Bowmans Creek Wind Farm (SSD-10315)
Request for additional information

I refer to the assessment of the Bowmans Creek Wind Farm (SSD-10315). The Department is requesting that you provide additional information on the matters outlined below.

Photomontage view from F18-1 Dwelling: Approximate distance to turbine T59 is 3,260 metres **Viewpoint location:** E: 131119 N: 6427300 **Turbine dimensions:** 150m hub, 220m tip

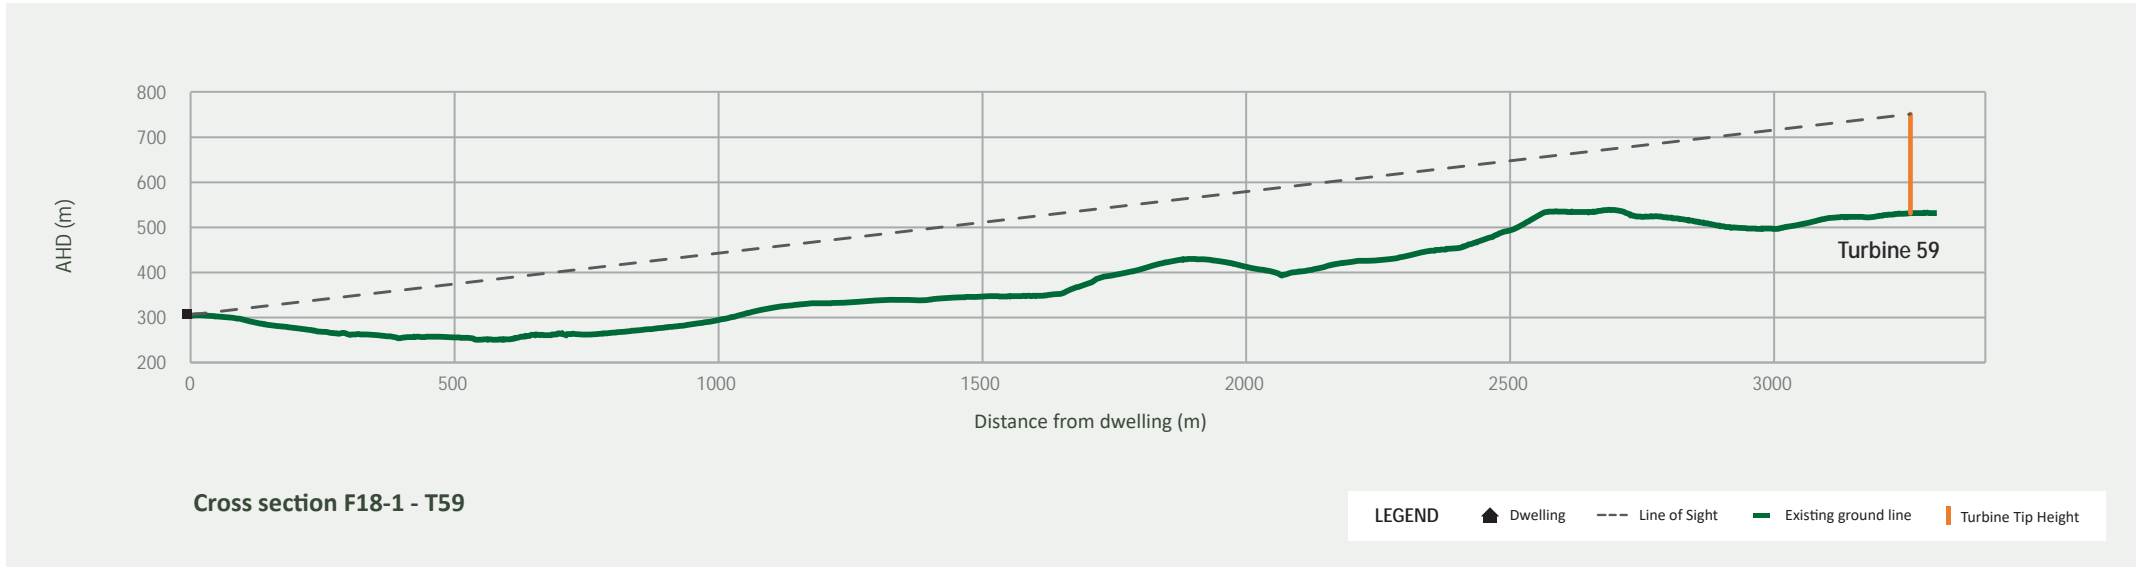
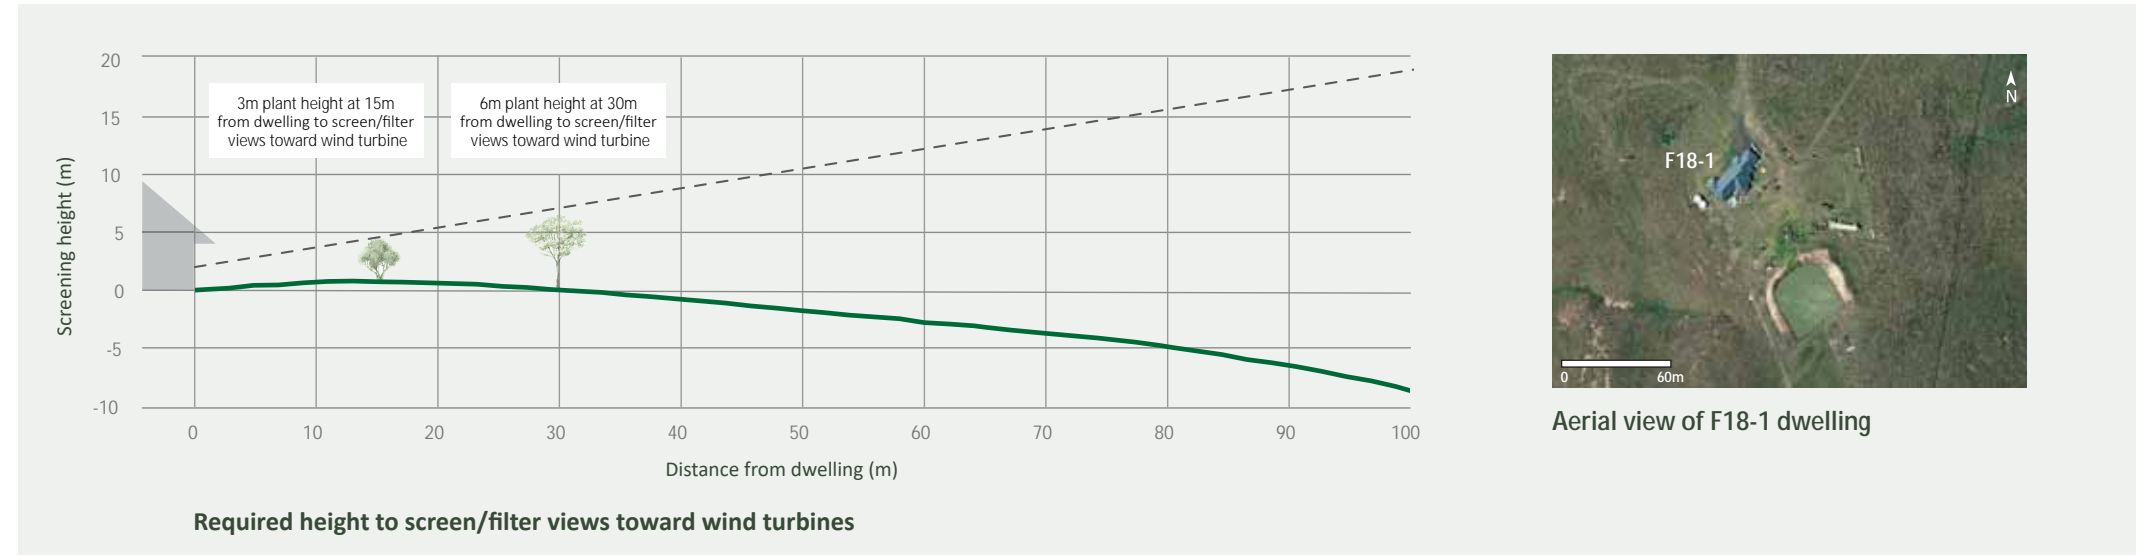
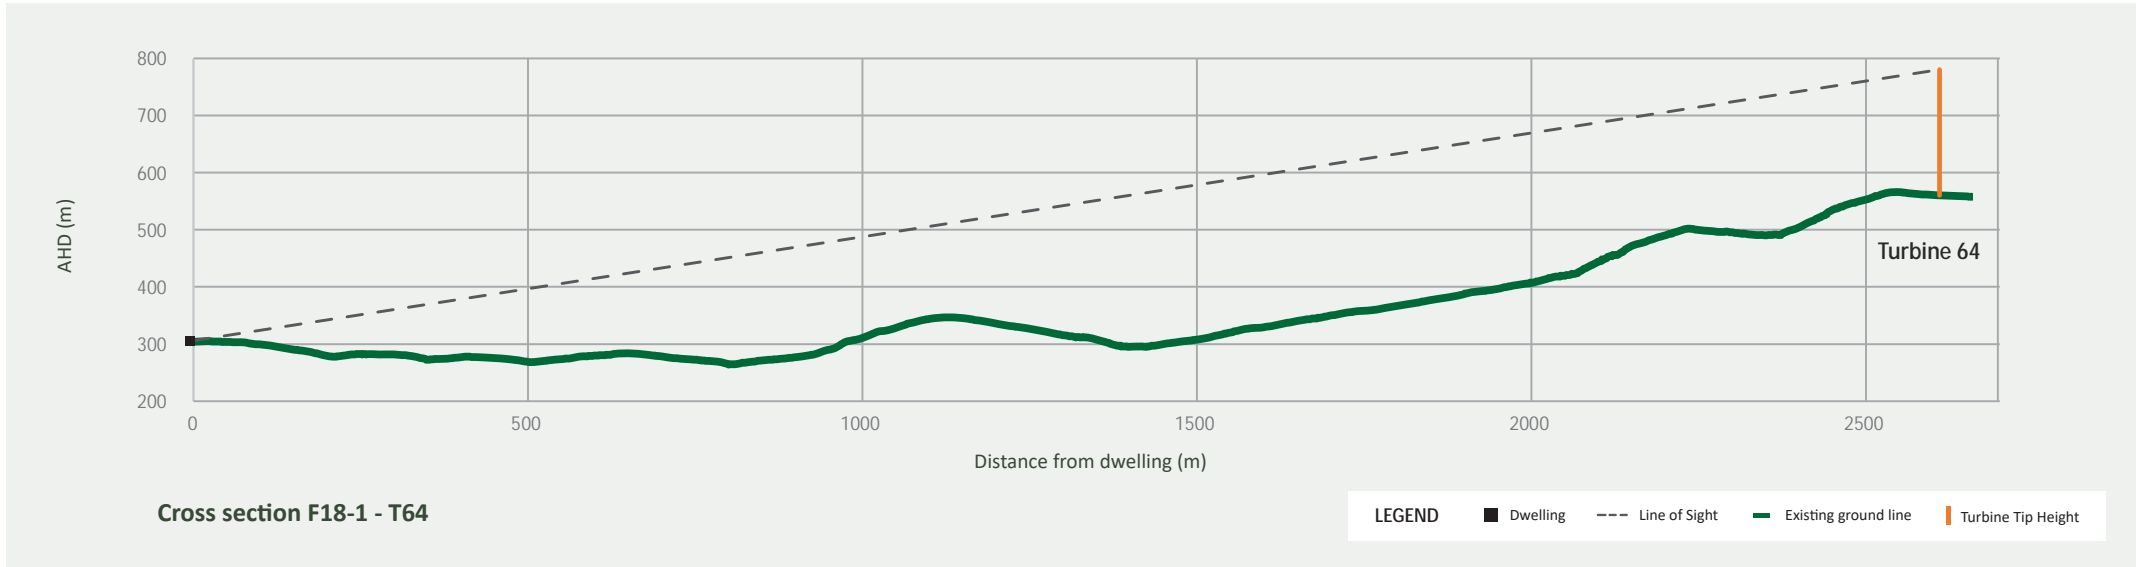
- *Photomontages / Wireframes:* provide for the following:
 - residence F18-1;
 - residences Q17-1, Q17-2, Q17-3 (representative) capturing all potential views of turbines;
